**Re:** Project #1007649, 09EPC-40006, SDP for Building Permit, Indian School Rd.

6. **Project# 1007649**  
11DRB-70247 EPC APPROVED SDP  
FOR SUBDIVISION

Development Review Board Comments

**Project Number:** 1007649  
**Application Number:** 11DRB-70247

INDIAN SCHOOL AND BROADWAY SITE DEVELOPMENT PLAN FOR SUBDIVISION

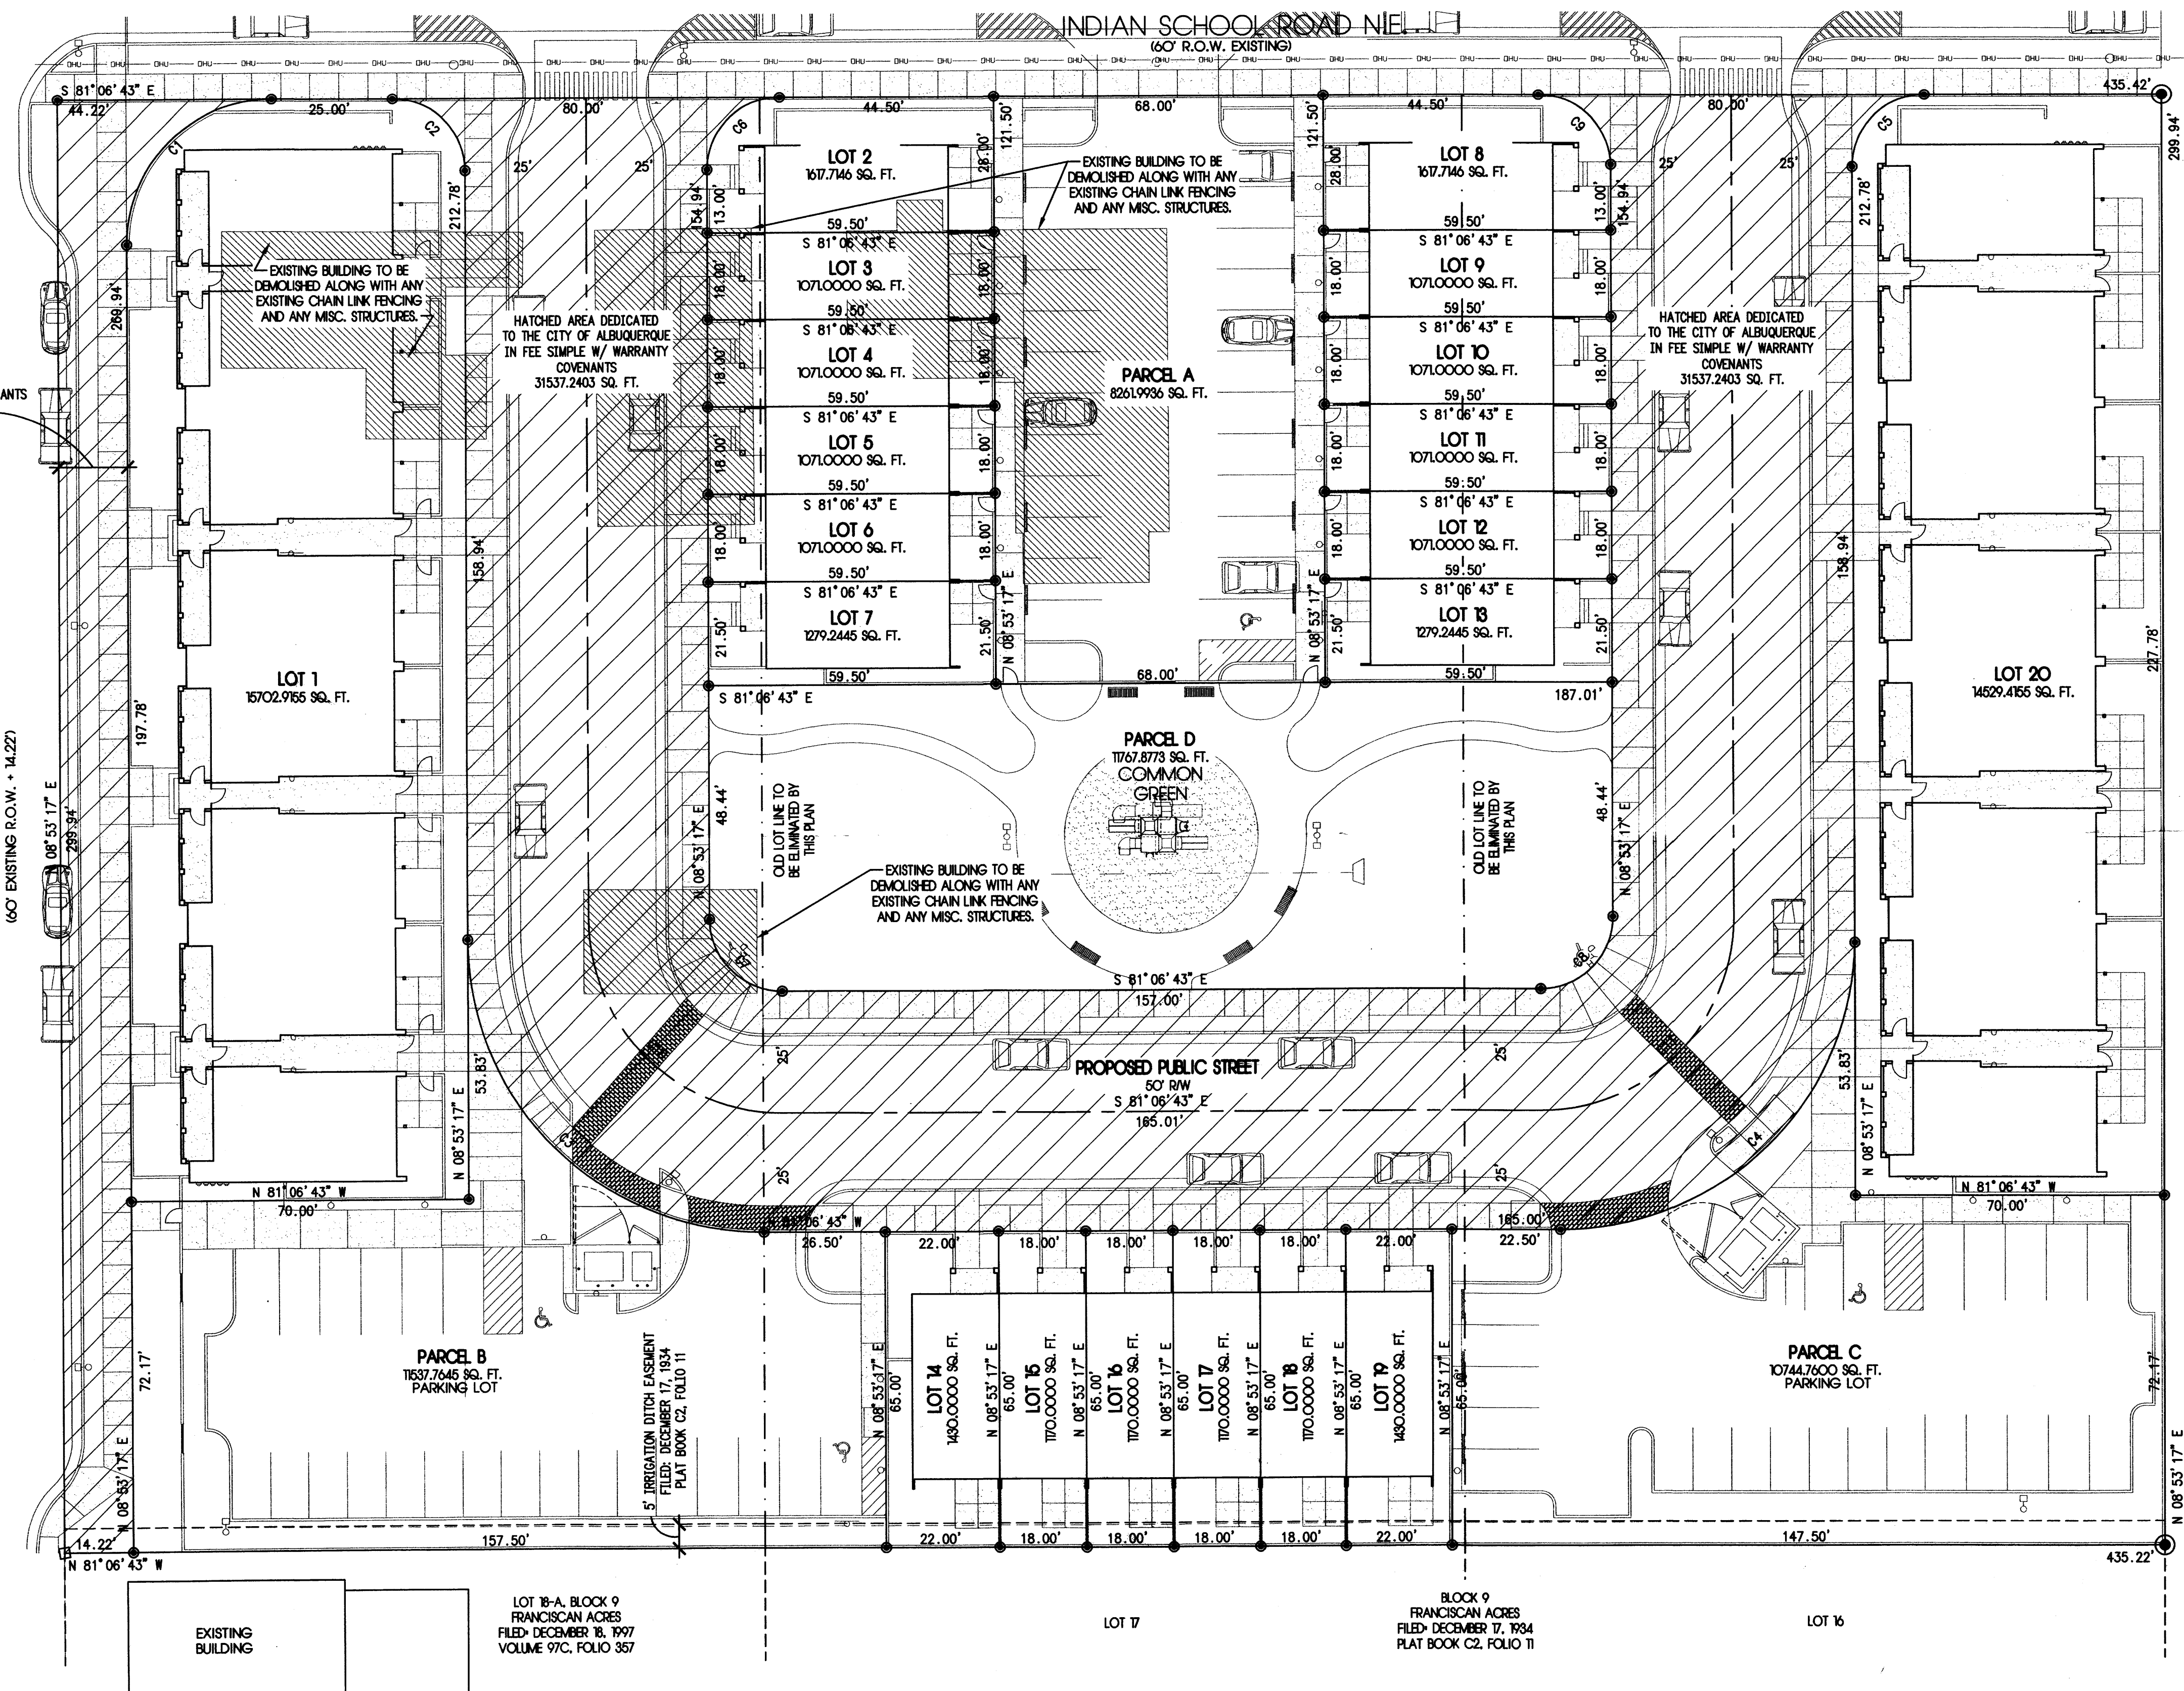
Add note to common green area to be developed and maintained by HOA.

Clarify if this is a site plan for building permit or subdivision.
